1. Mosman High School – Response to Submissions

ptc. has been engaged by Multiplex on behalf of School Infrastructure NSW (SINSW) to address comments received following the State Significant Development Application (SSDA) submission of the Mosman High School project located at 745 Military Road, Mosman.

Figure 1 – AV Entry and Exit Routes

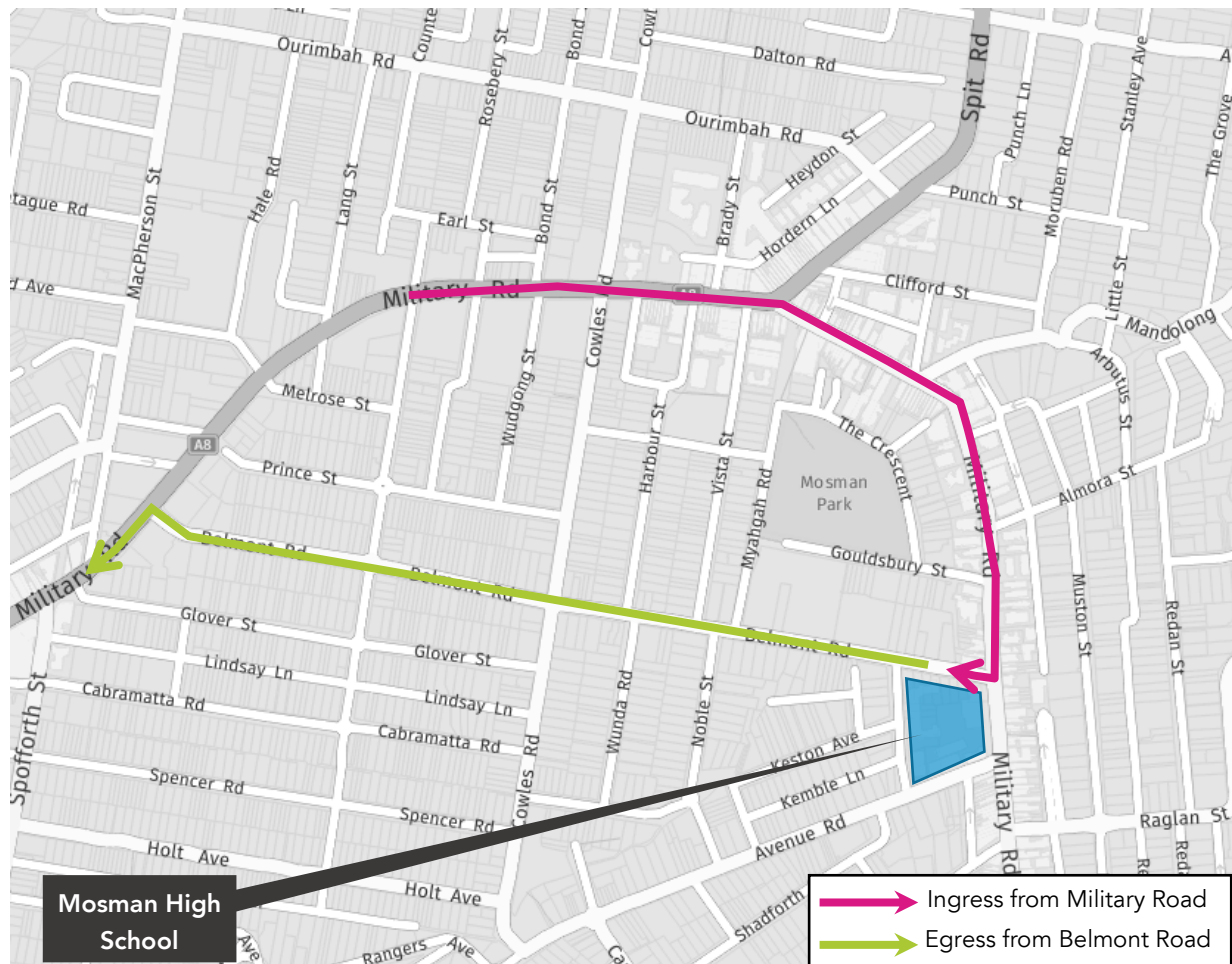
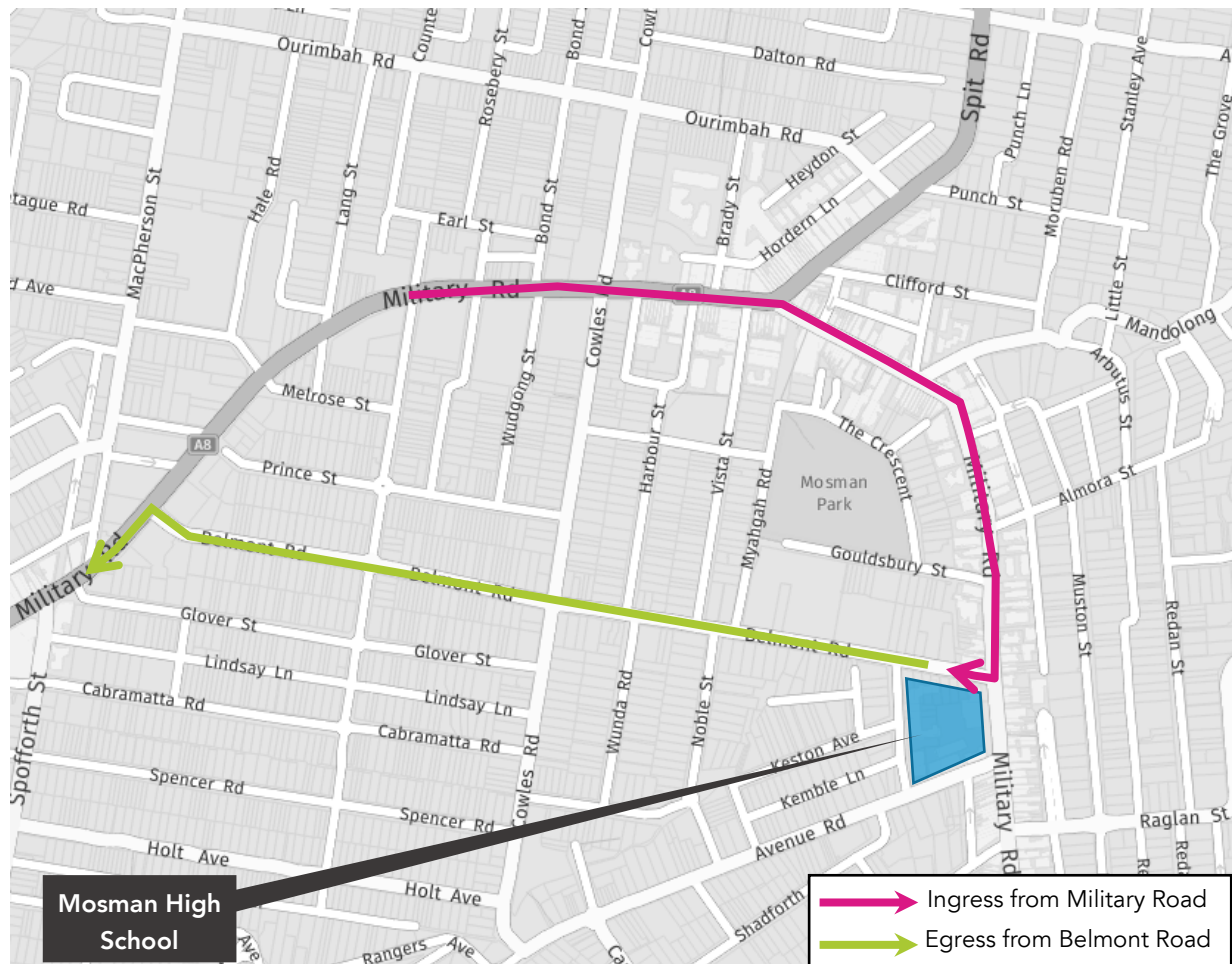
The swept path diagrams within the CTMP are not clear enough for TfNSW to complete the assessment and provide comment.

It is requested that the Proponent to submit the swept path diagrams in DWG format to TfNSW for review.

The swept path diagrams will be provided in DWG format for TfNSW's assessment.
